DEVELOPMENT REVIEW BOARD SUPPLEMENTAL SUBMITTAL

PROJECT NO. 1004000/ PR-2018-0001
Application No. SI-2018-00031

SUBMITTAL DESCRIPTION: Updated Plan Set with comments

**RE: PRIMROSE DRB PROJECT NUMBER: 2018-001183 (1004000)
SITE DEVELOPMENT PLAN FOR BUILDING PERMIT**

PRIMROSE SCHOOL OF NW ALBUQUERQUE	DRAWN BY
	SITE PLAN FOR BUILDING PERMIT	DATE
	TIERRA WEST, LLC 5571 MIDWAY PARK PL NE ALBUQUERQUE, NEW MEXICO 87109 (505) 858-3100 www.tierrawestllc.com	DRAWING
		SHEET #
		1
		JOB #
		2017092

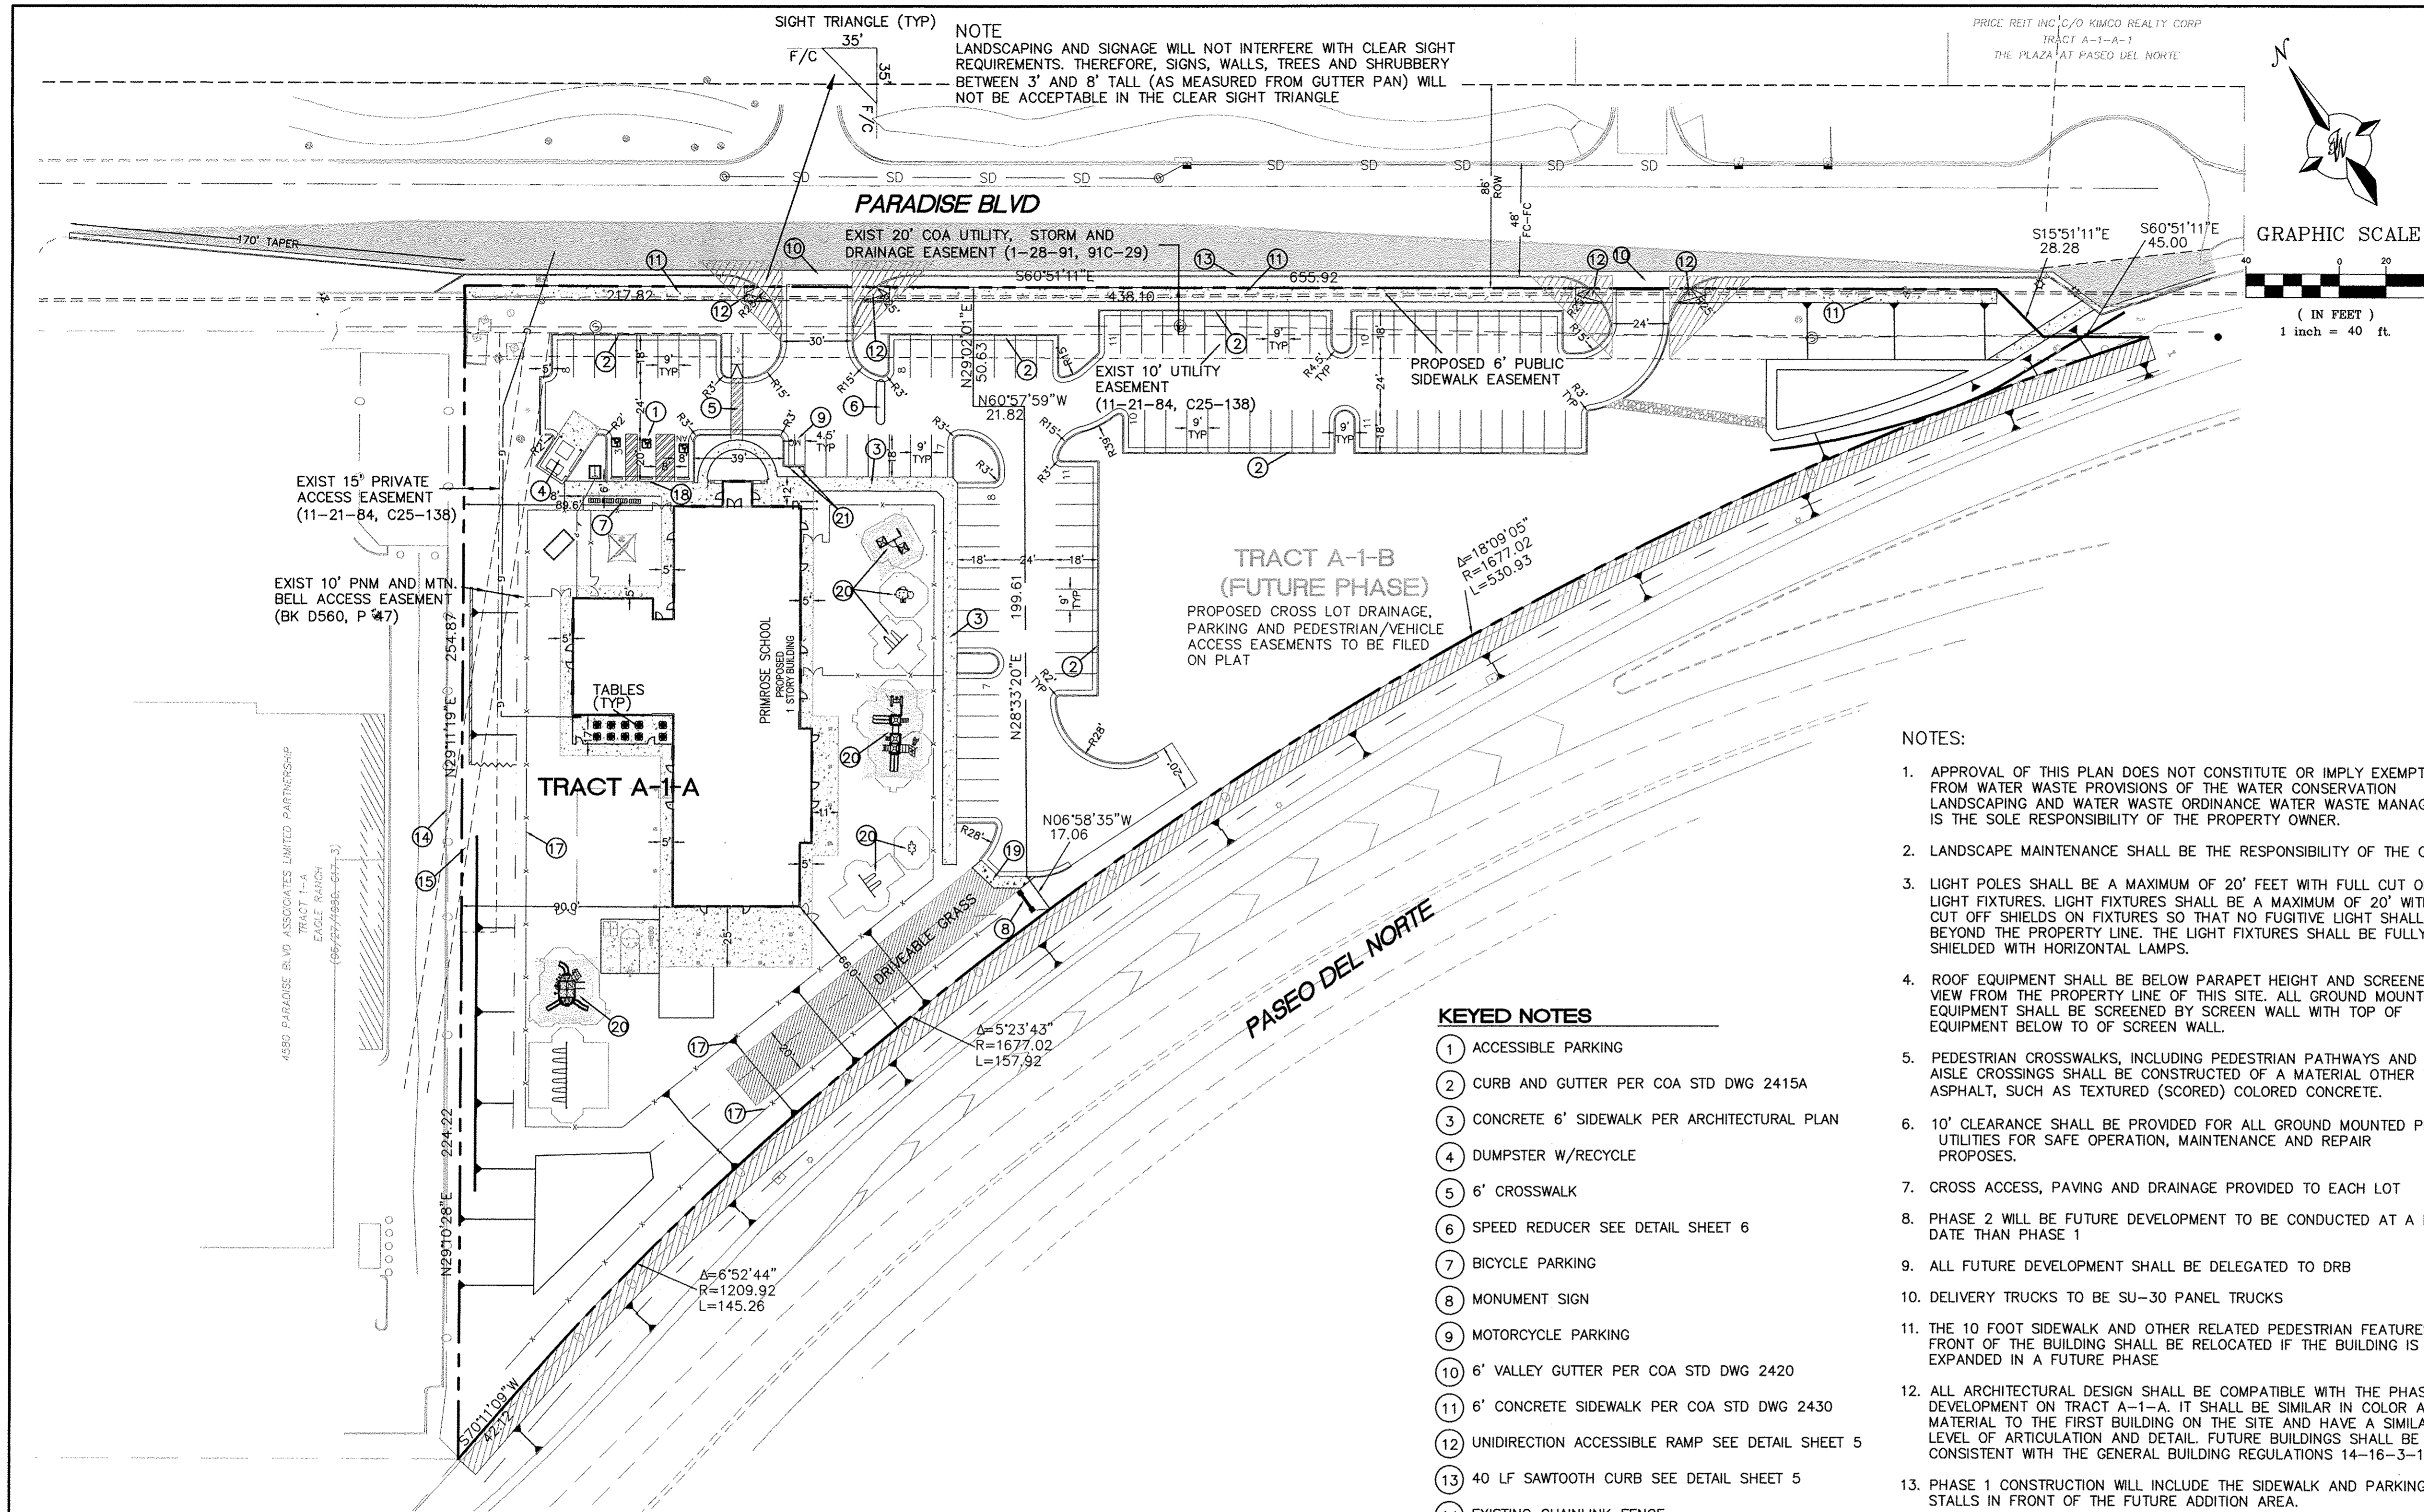
1. Remove ramp at NW corner of the site and place sidewalk at property line.
The ramp was removed.
2. Provide sidewalk width on site around playground.
Dimensions were added to all of the sidewalks around the playground.

6. A cross lot access easement is required.
A cross lot access easement is noted on Sheet 1 and will be provided on the plat.

PRIMROSE SCHOOL OF NW ALBUQUERQUE CONCEPTUAL GRADING PLAN	DRAWN BY pm DATE 6-27-18 DRAWING
		TIERRA WEST, LLC 5571 MIDWAY PARK PL NE ALBUQUERQUE, NEW MEXICO 87109 (505) 858-3100 www.tierrawestllc.com

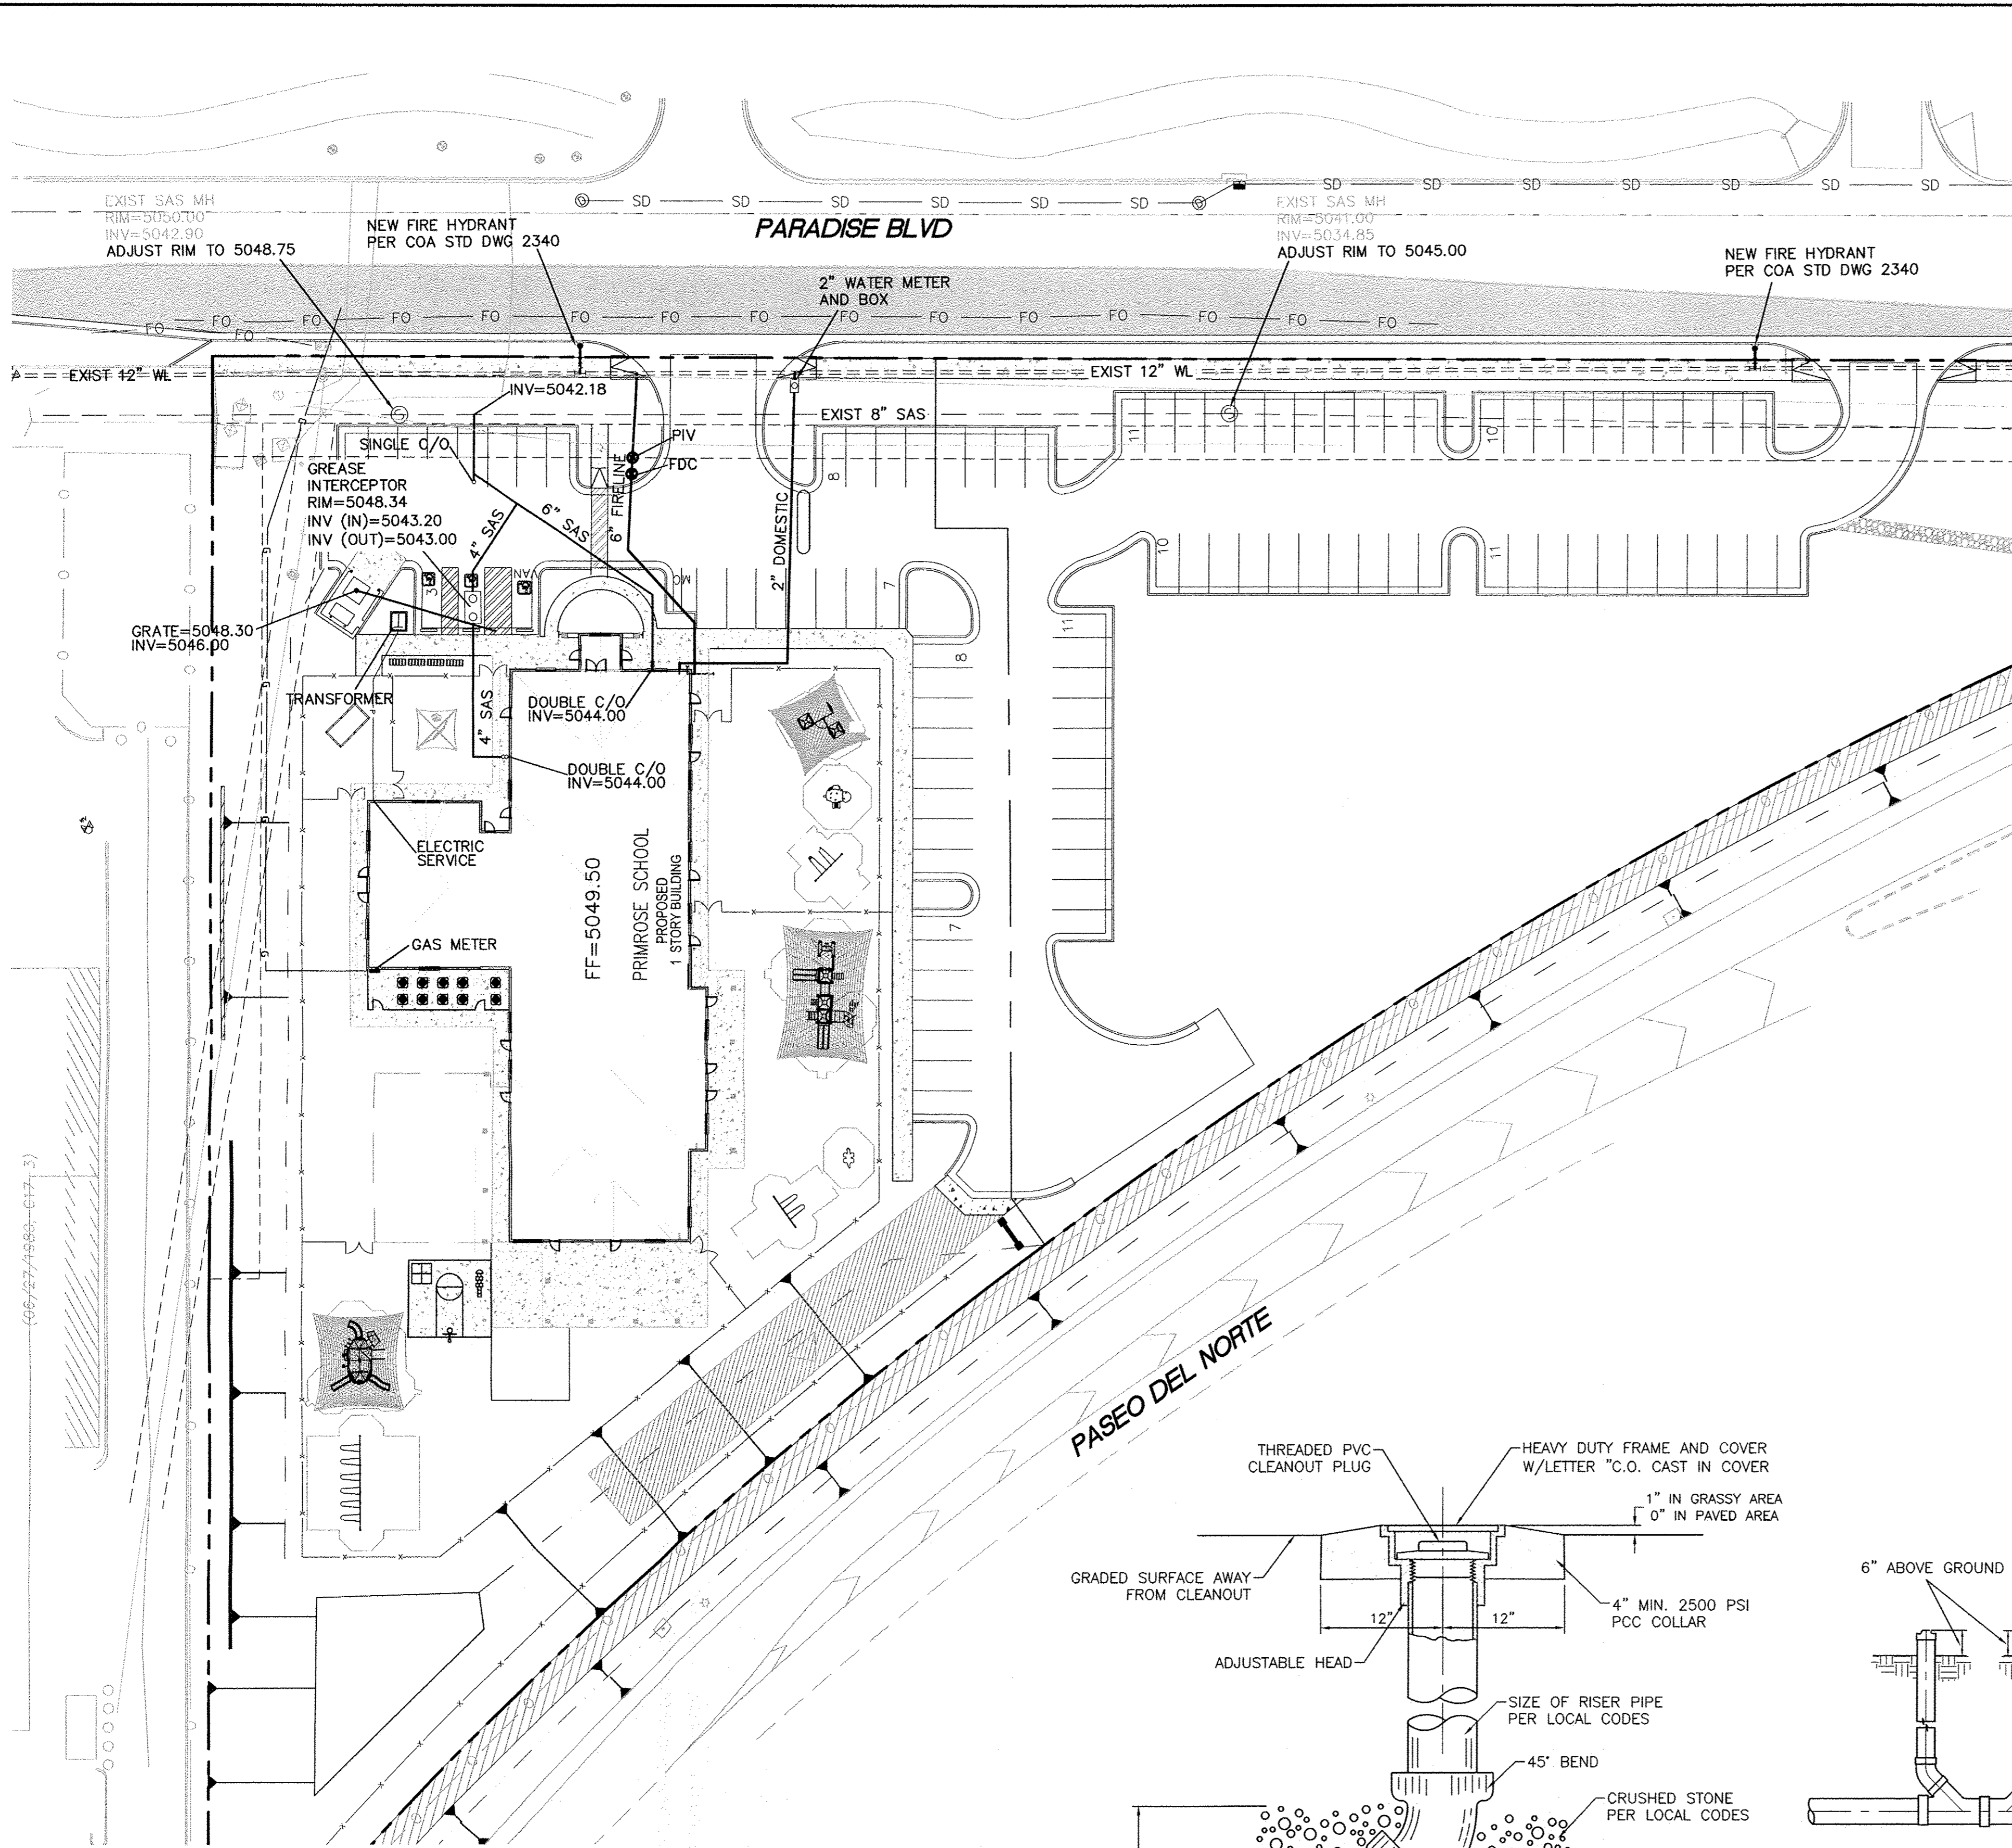
1. Revisions are still required to the Grading and Drainage Plan.
A revised Conceptual Grading Plan and Drainage Report was submitted to Hydrology on June 26th.
2. Hydrology recommends that any necessary revisions to the previously approved Infrastructure List be made prior to Work Order.
Base on the revised Grading Plan and Drainage Report there are no public drainage facilities required for this project.

PRIMROSE SCHOOL OF NW ALBUQUERQUE	DRAWN BY: pm
	CONSTRUCTION DETAILS	DATE: 7-11-18
		DRAWING:
		SHEET #:
		6
		JOB #: 2017092

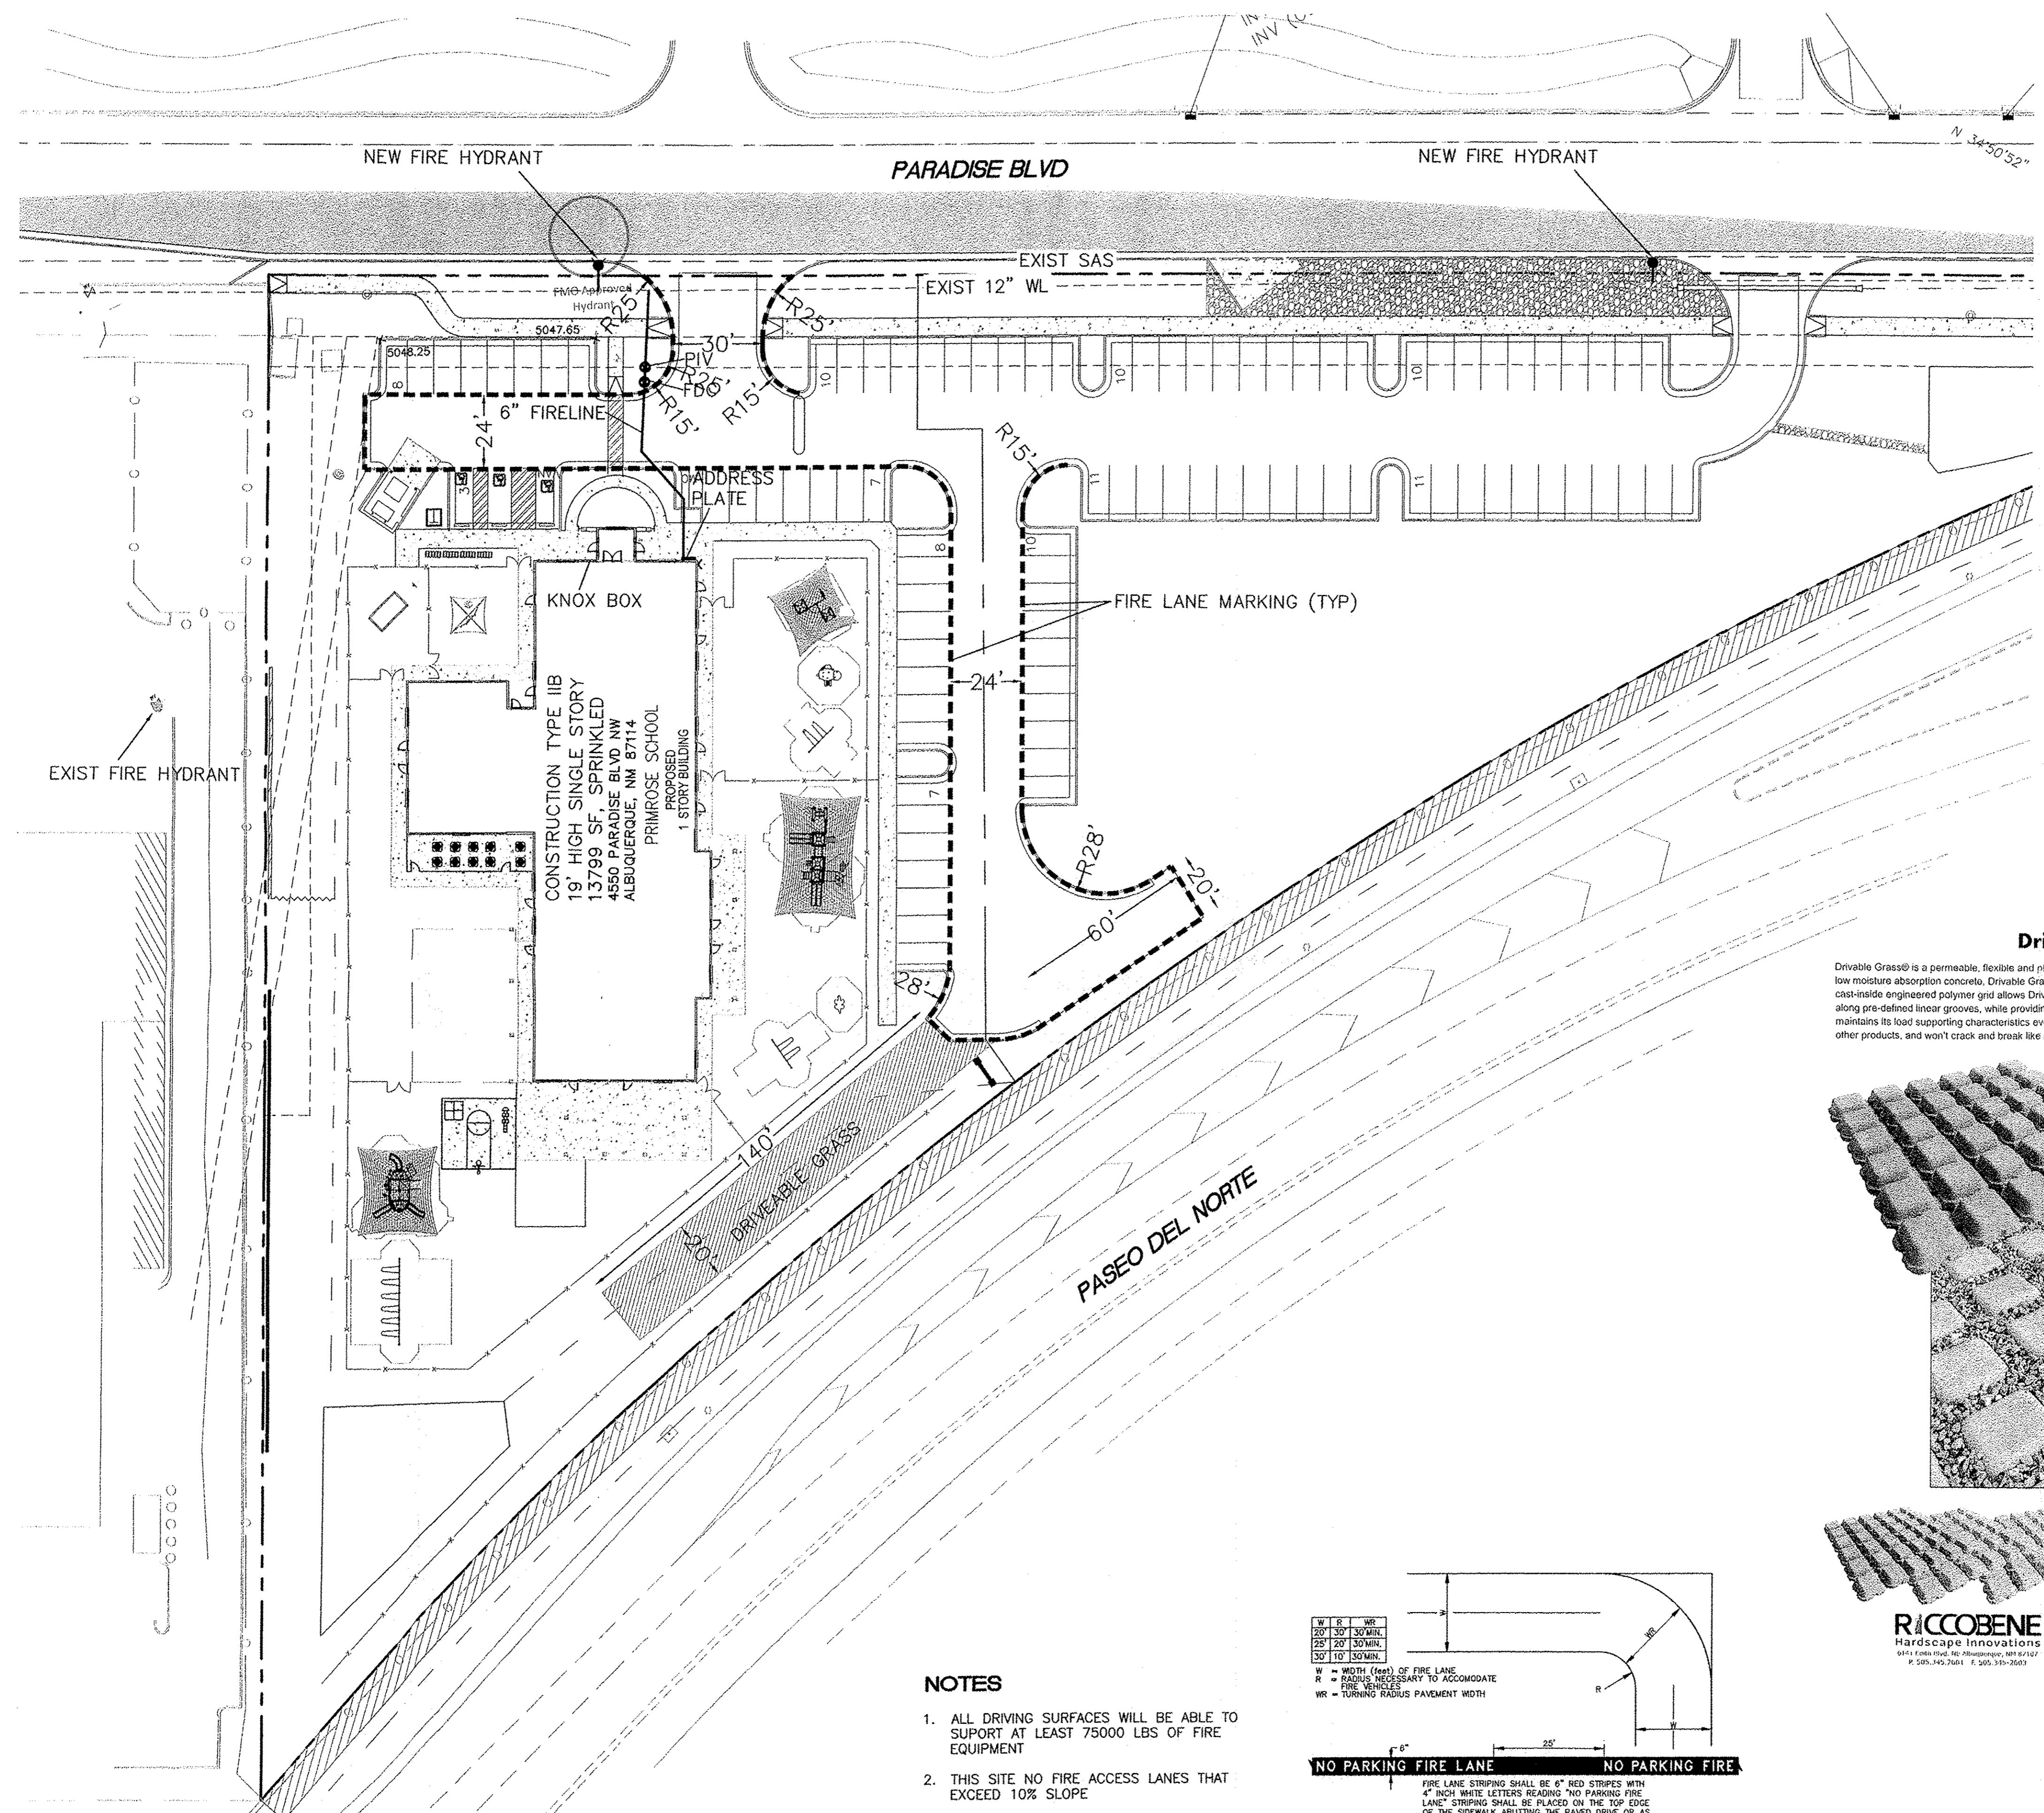
3. Provide detail for "speed reducer".
The speed reducer detail is found on Sheet 6.
4. Verify with NMDOT whether sidewalk along Paseo del Norte is required.
We have contacted NMDOT and they are reviewing if they need the sidewalk or not. We should receive a response back from them prior to the DRB Hearing. We have left it on the plans for now and will update the sheets if it is not required.
